**KIRKLEES METROPOLITAN COUNCIL
INVESTMENT & REGENERATION SERVICE**

Reference No: 2017/62/93318/W

Site Address: 259, New Hey Road, Oakes, Huddersfield, HD3 4GH

Description: Erection of two storey side extension with basement floor under to rear and dormer window to rear

Drawing 660-02 PLANS & ELEVATIONS
AS PROPOSED

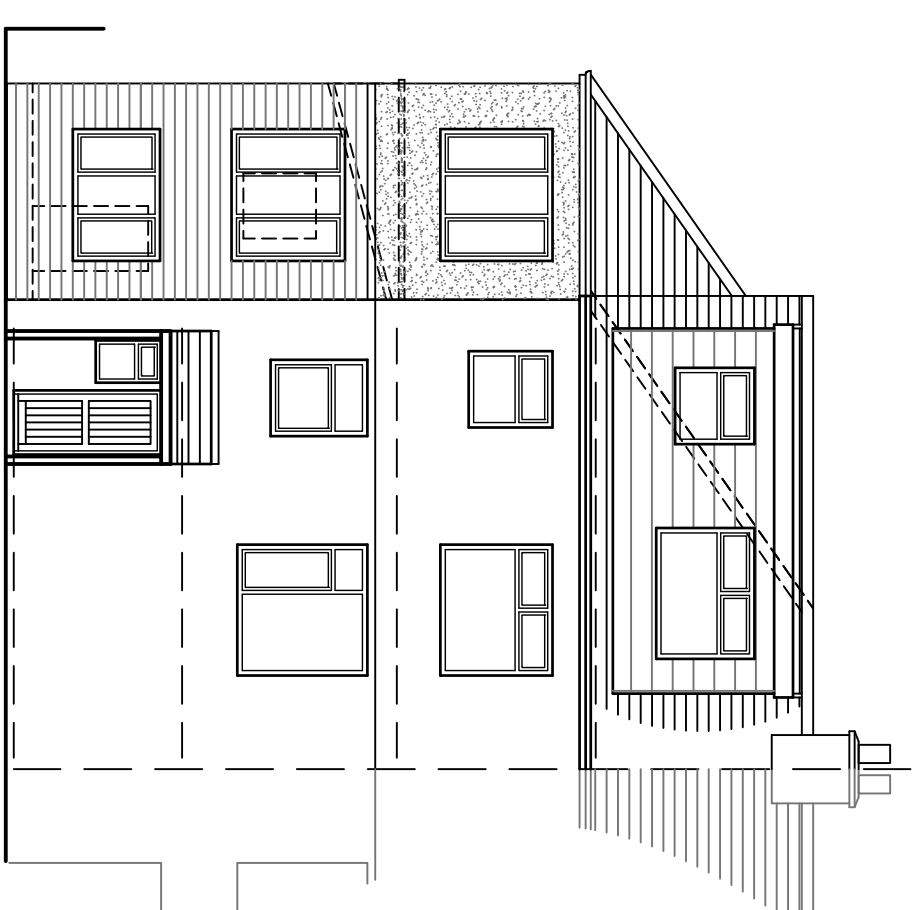
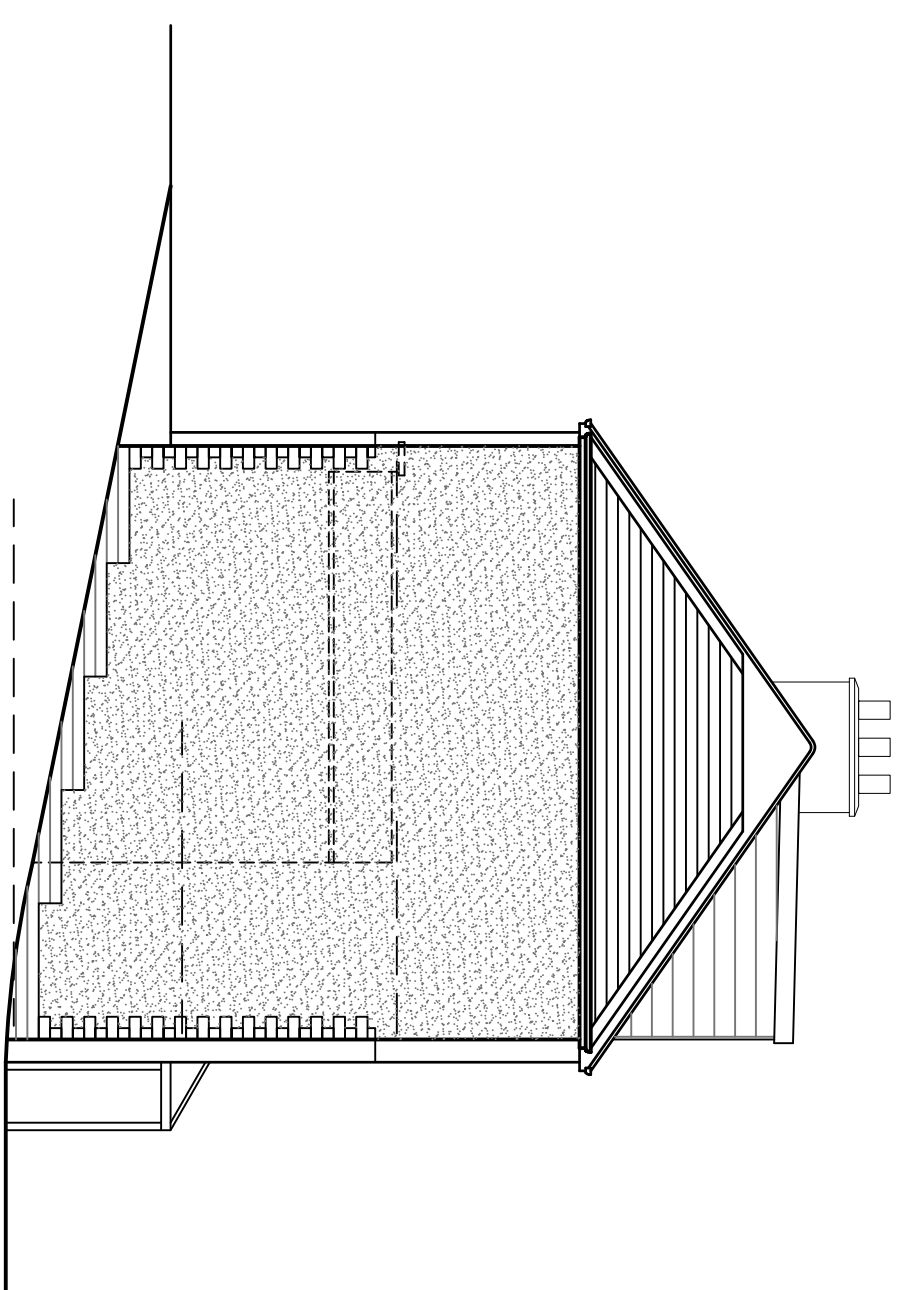
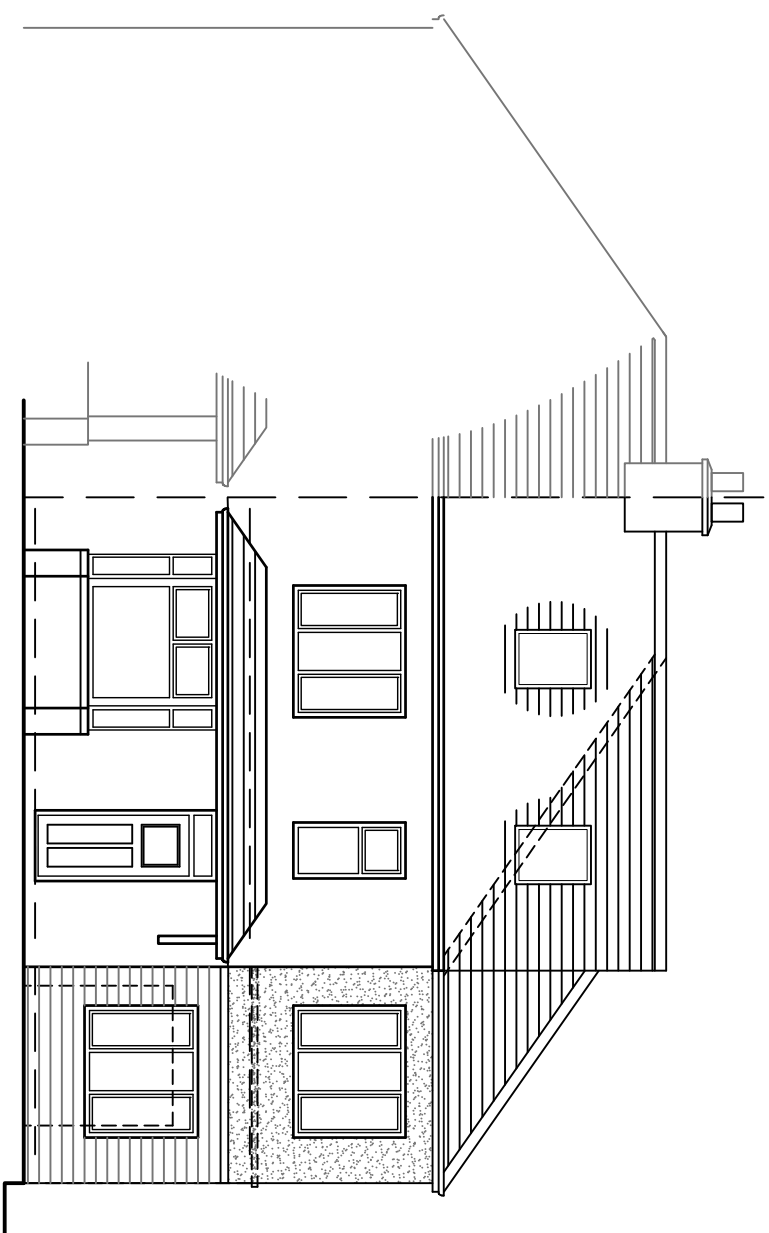
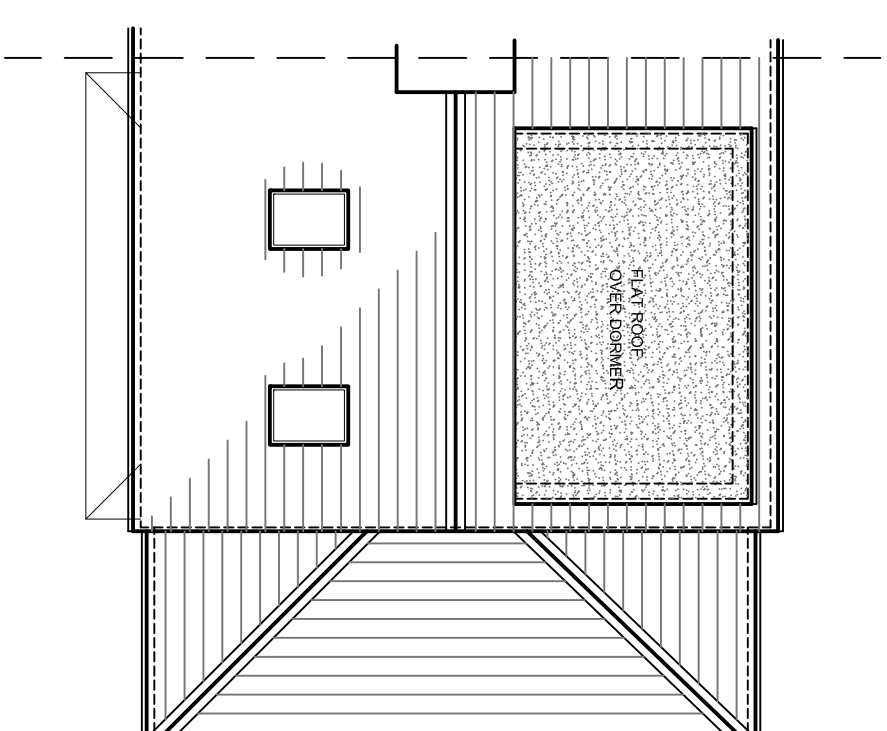
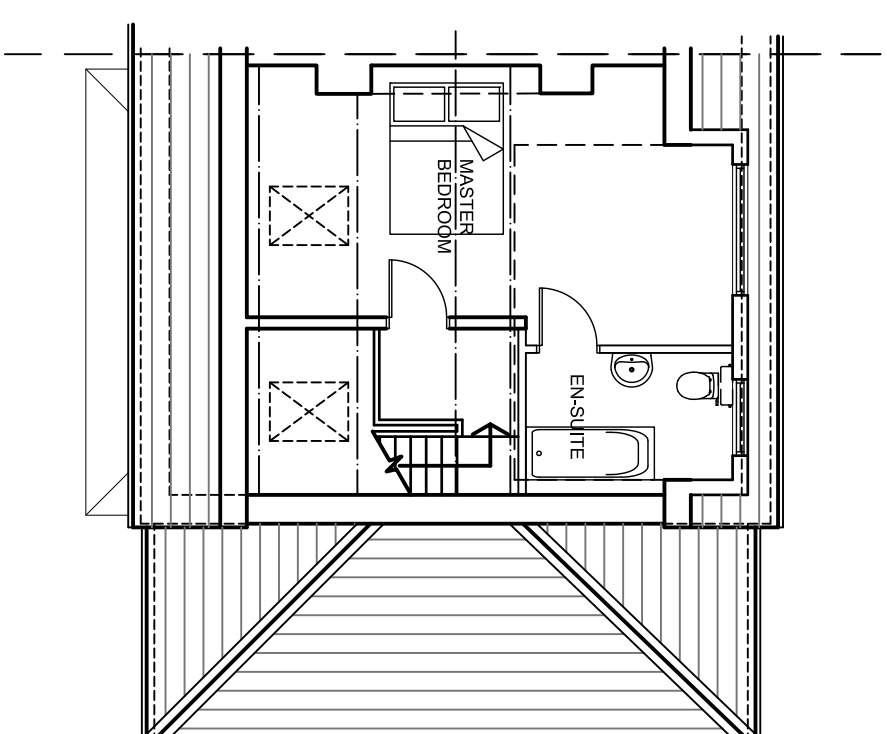
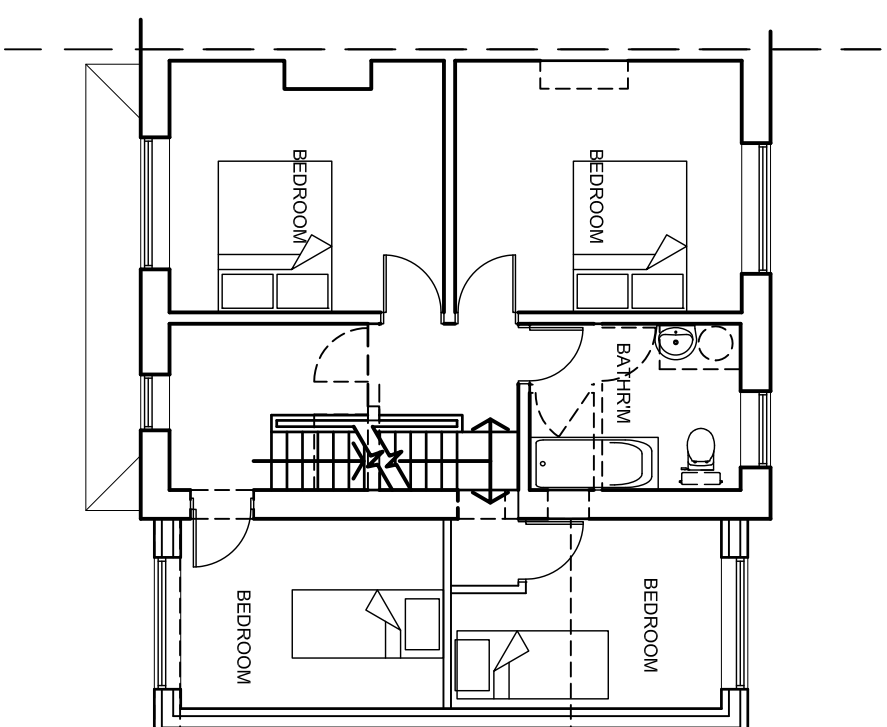
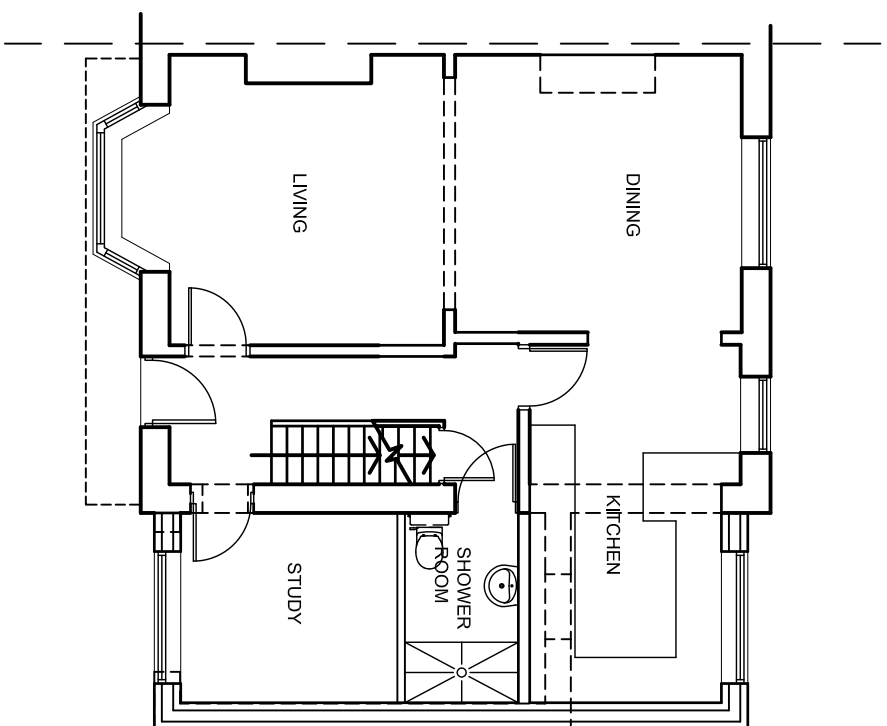
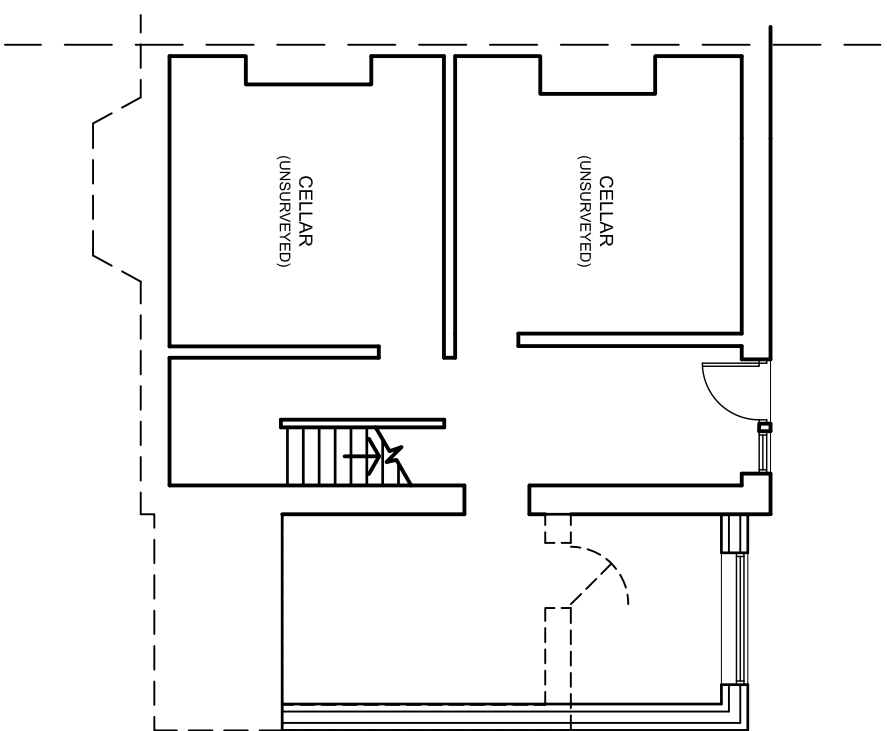
3. Notwithstanding the details proposed, the use of white uPVC cladding for the dormer window is not approved. The front and sides of the dormer shall be clad in dark grey material to harmonise with the roof of the dwelling before the room it serves is first brought into use. It shall thereafter be retained clad in dark grey material to harmonise with the roof of the dwelling.
